CITY OF ALBUQUERQUE

PLANNING DEPARTMENT – Development Review Services

**Re: Hydraulic Analysis Addendum to the Amendment to the DMP Trails Units 1,2,
and 3
Drainage Report, Engineer's Stamp Date 10-22-2014 (File: C09D001)**

City Project No.	Zone Map No.	PLATE 1
730084	C-9-Z

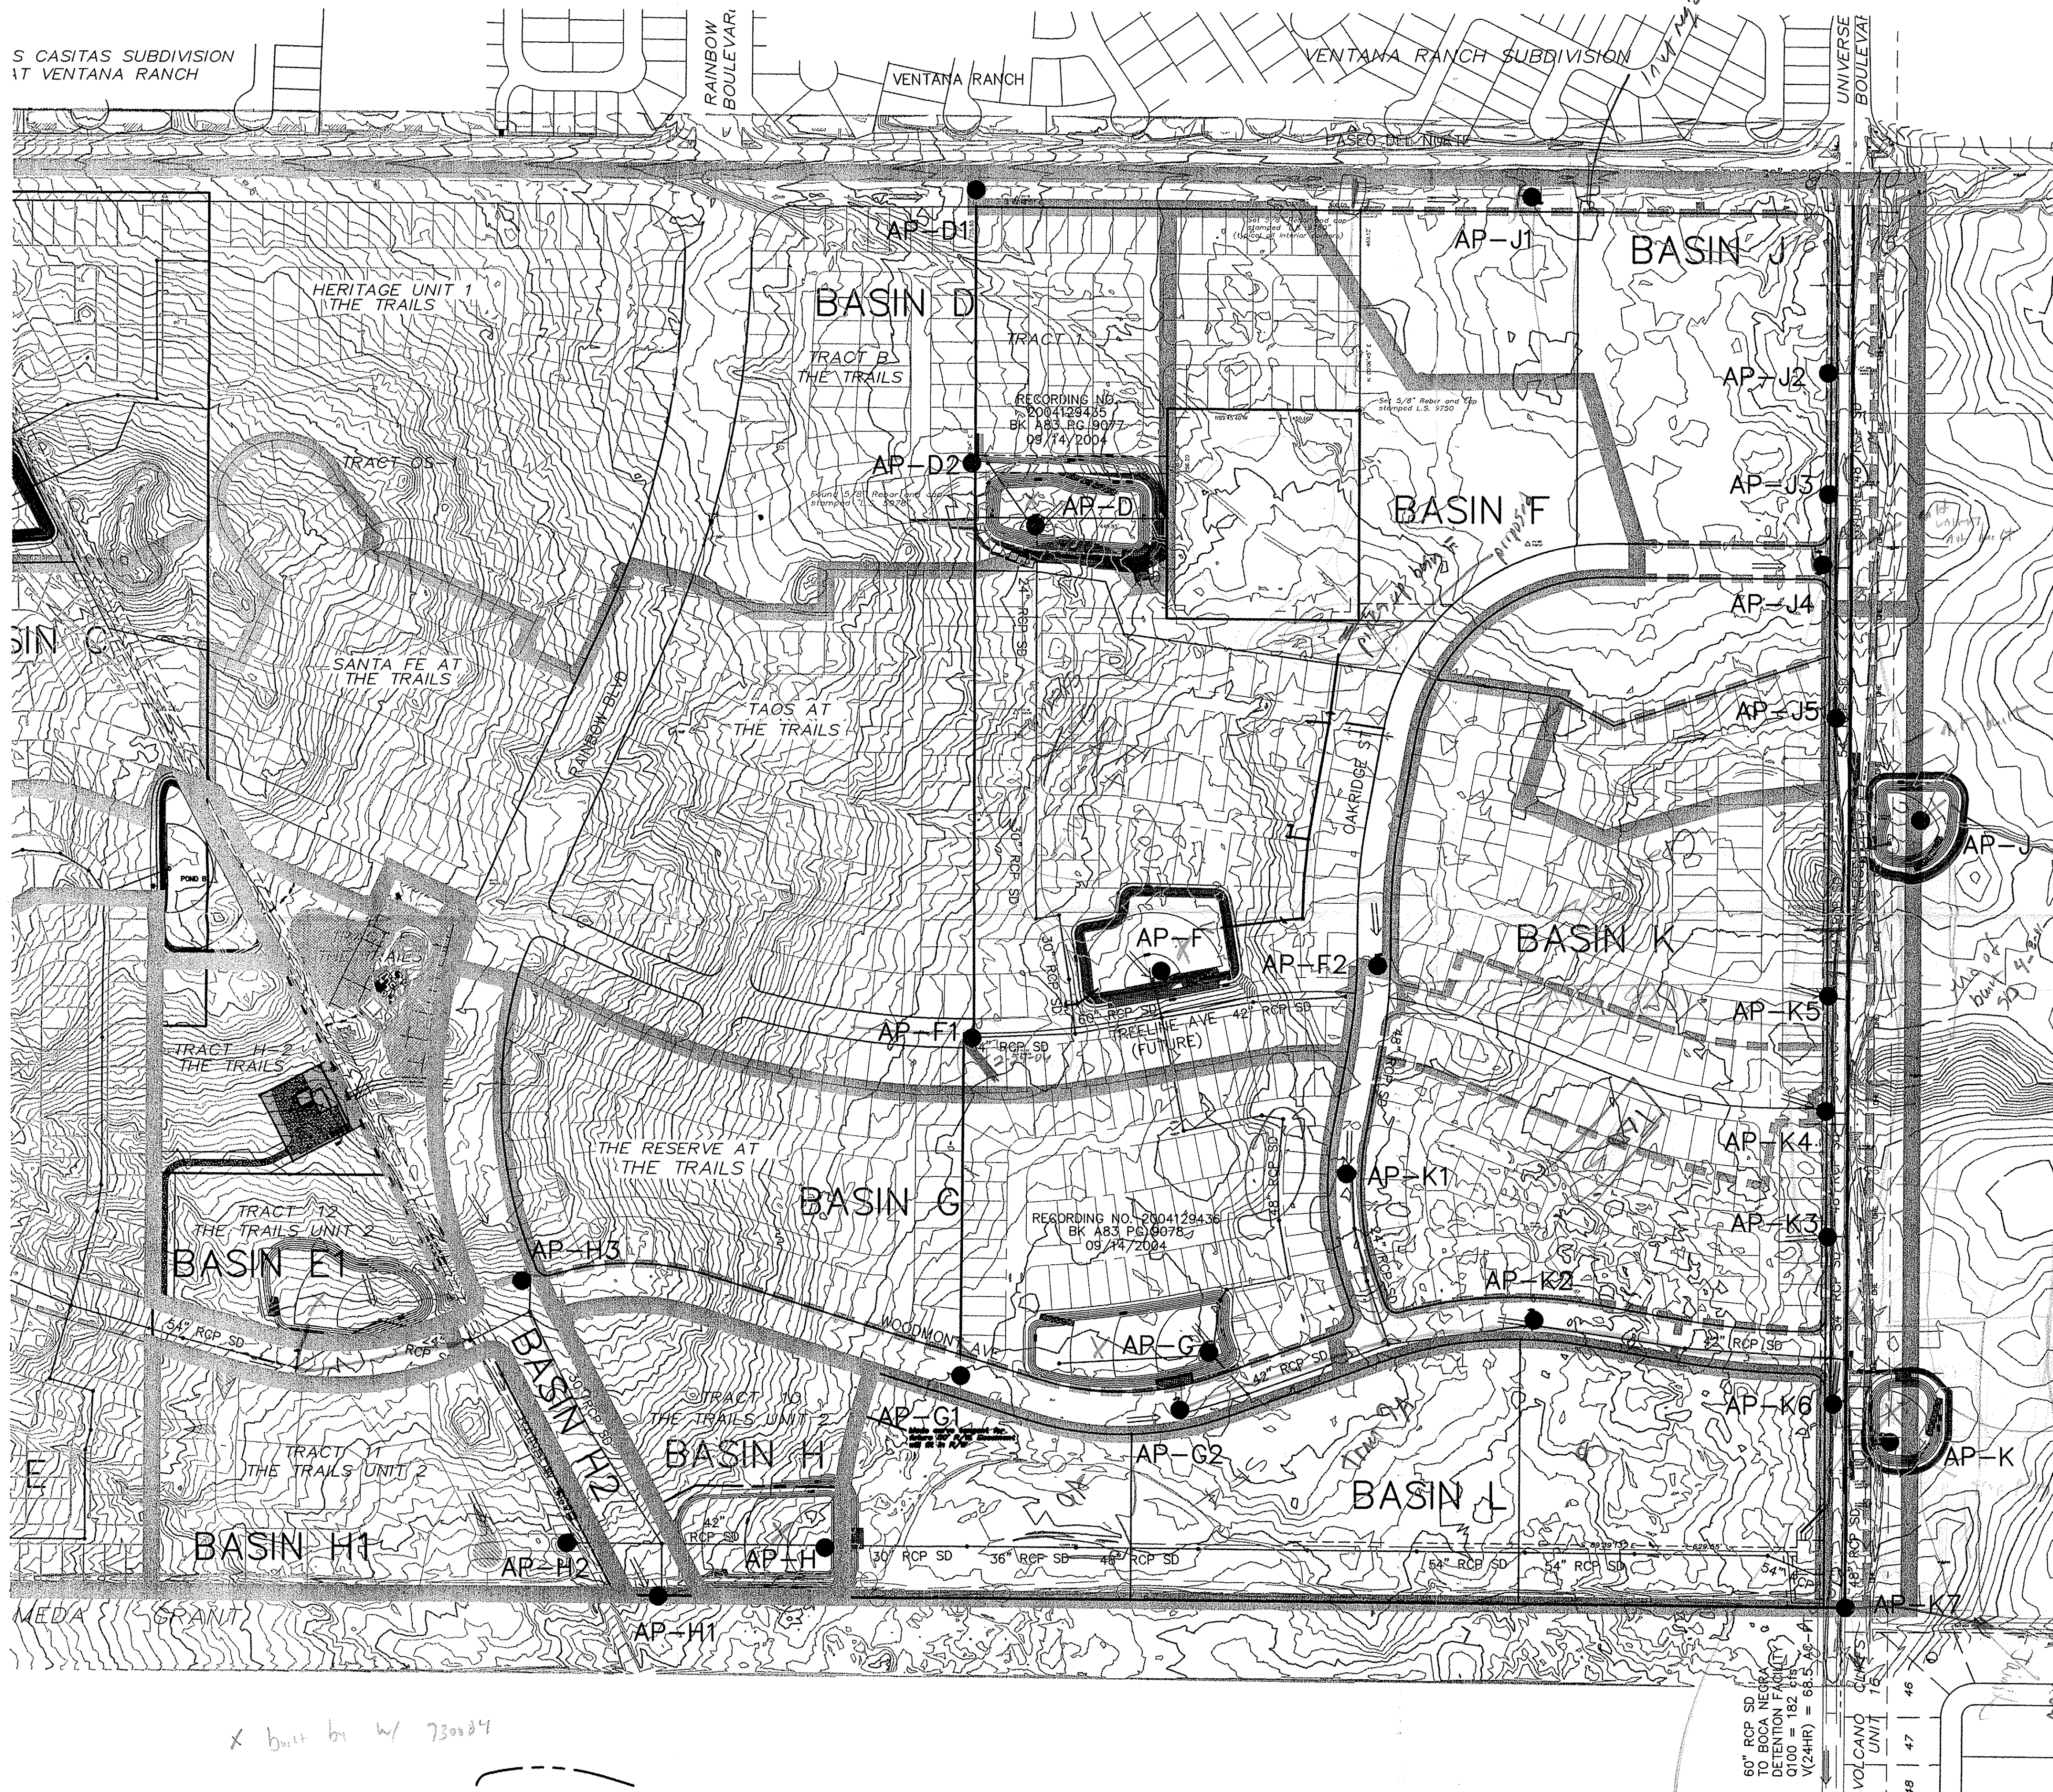
- There is an inflow Hydrograph associated with Pond F5 but is not noted on Plate 1. What basins or AHYMO ID is this hydrograph from? If this is from Basins D5 and D6, I would expect the peak to be about 42.44 cfs (the additions of peaks from both basins D5 and D6) but the peak of this hydrograph is 27.4 cfs.
- The SpillCrest in the XPSWMM model is 5428, but should be 5427.

PLATE 2

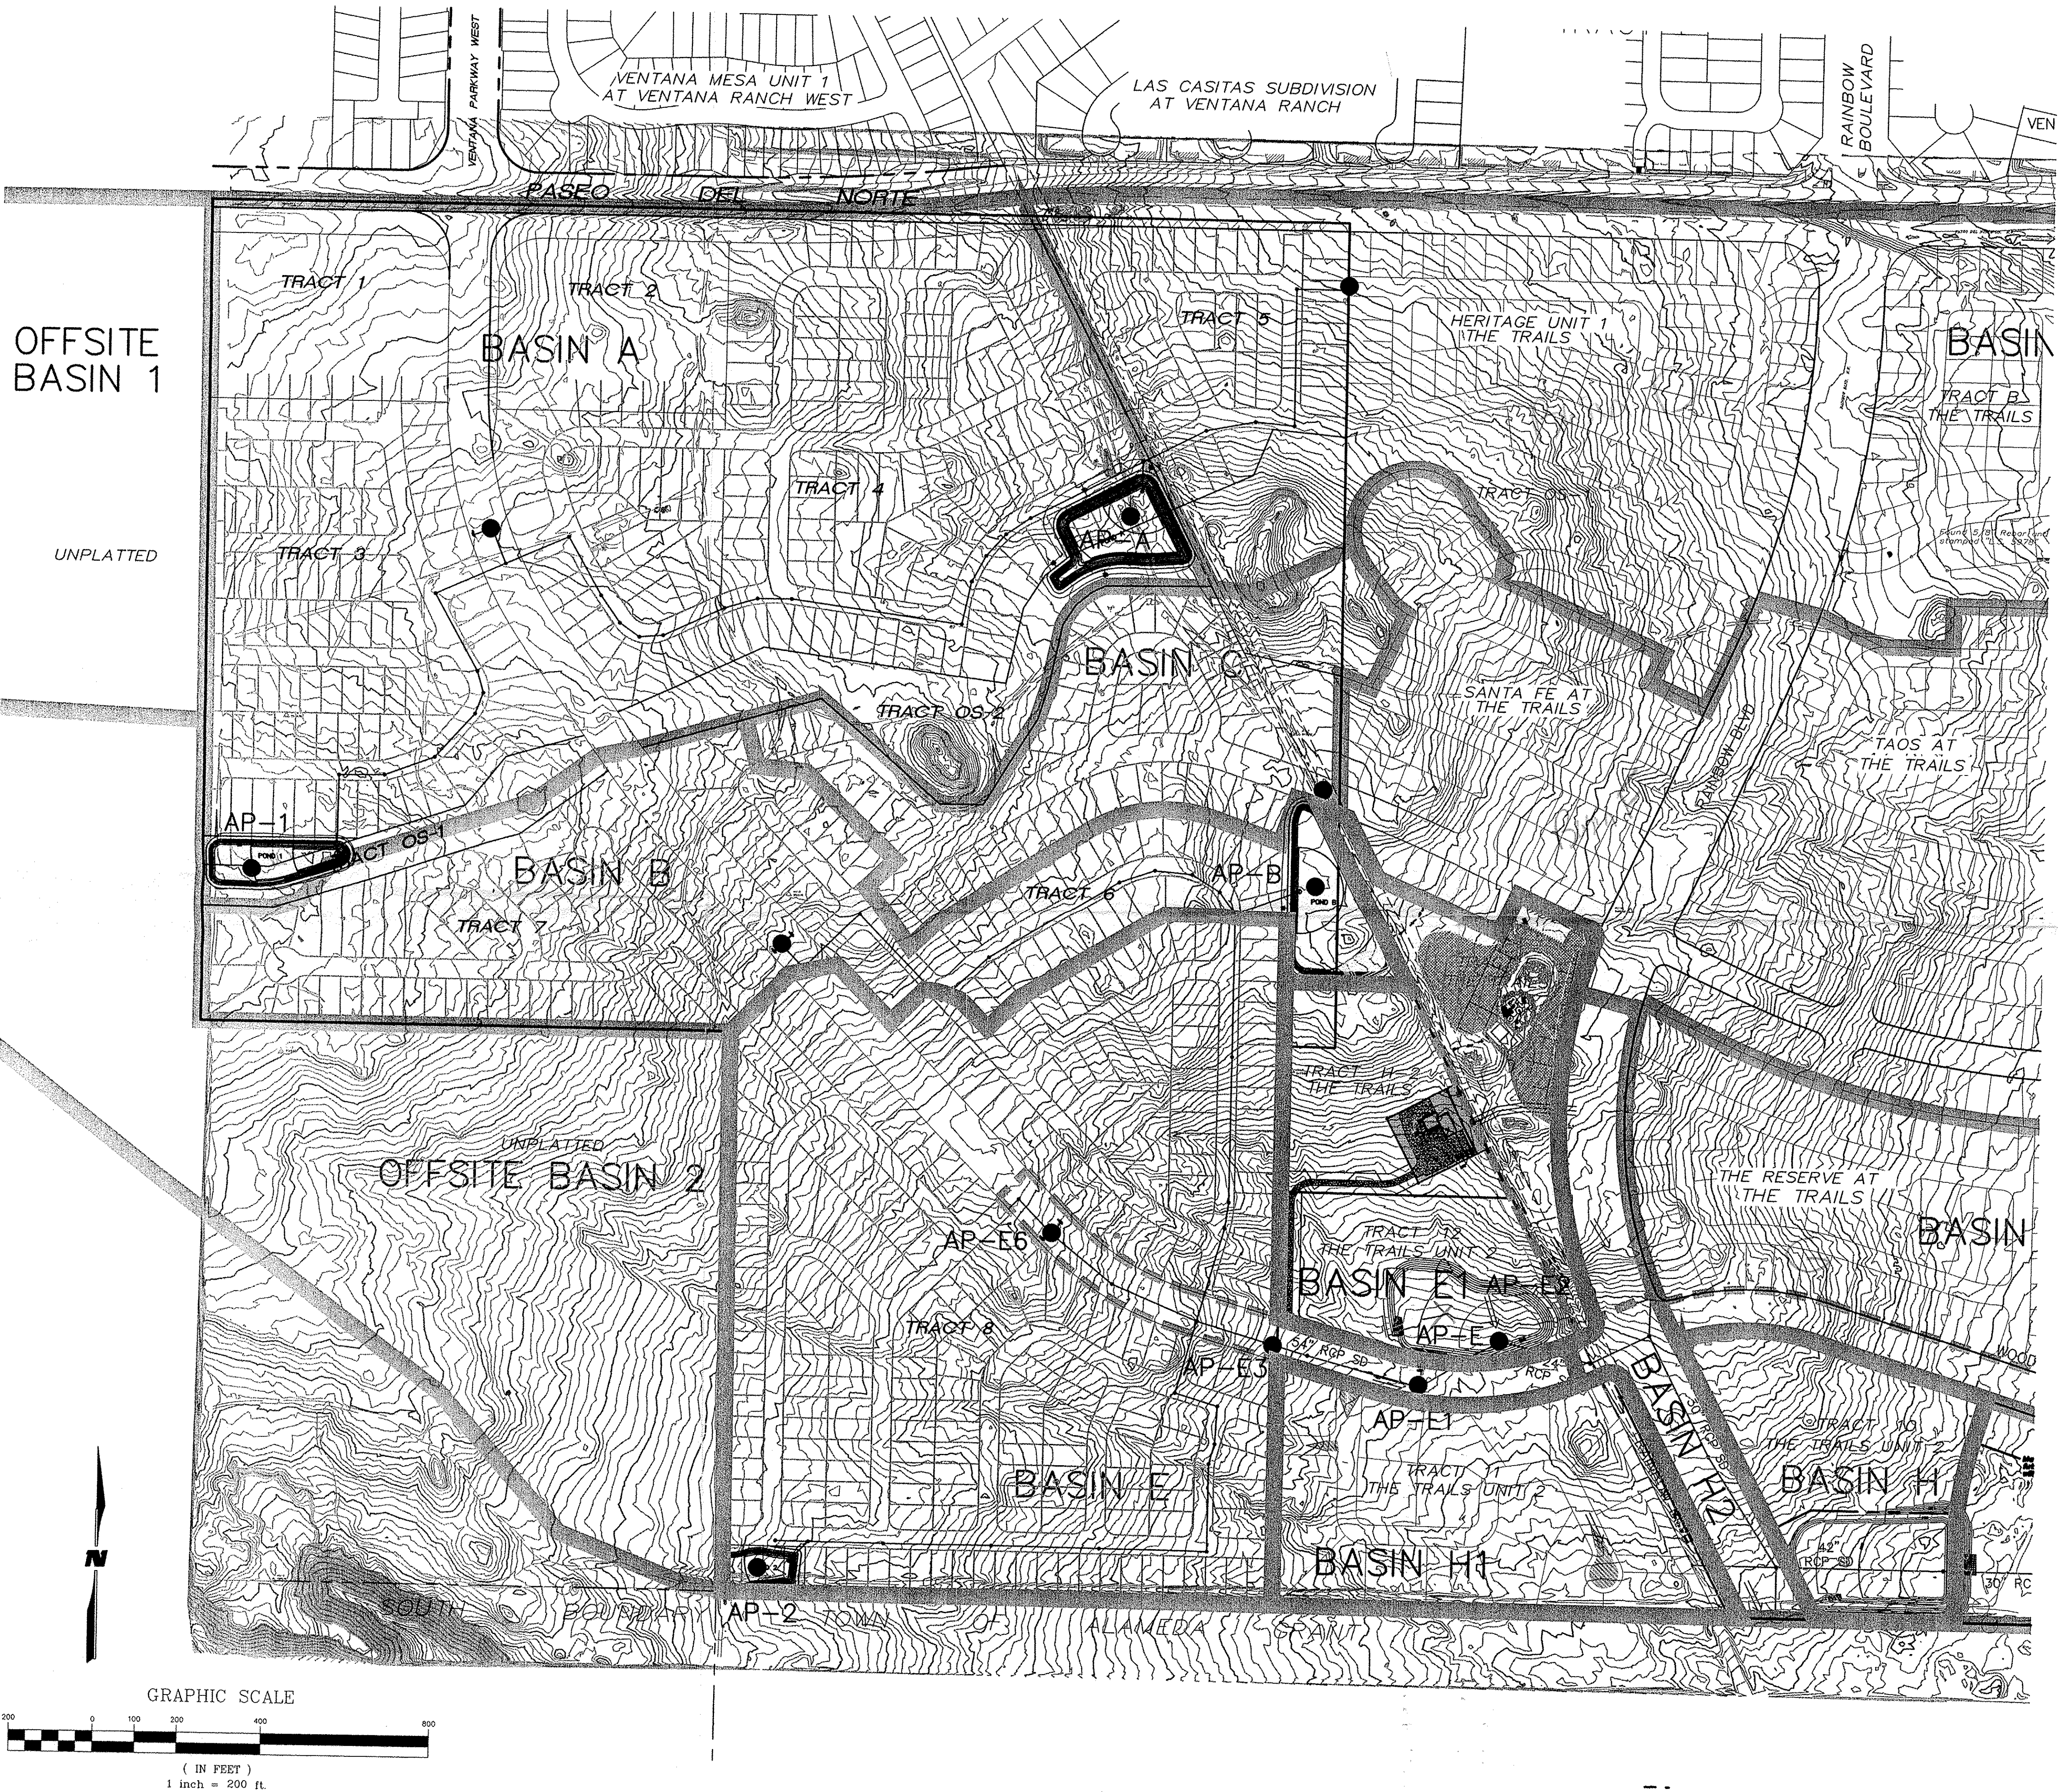
- o Provide printed forms of the "Inflow Hydrograph" at each node where AHYMO "punch hyds" were input. At each AHYMO ID, note which basins are included -or Plate 2 of TEC Trails DMP showing which basins are included in each AHYMO ID.
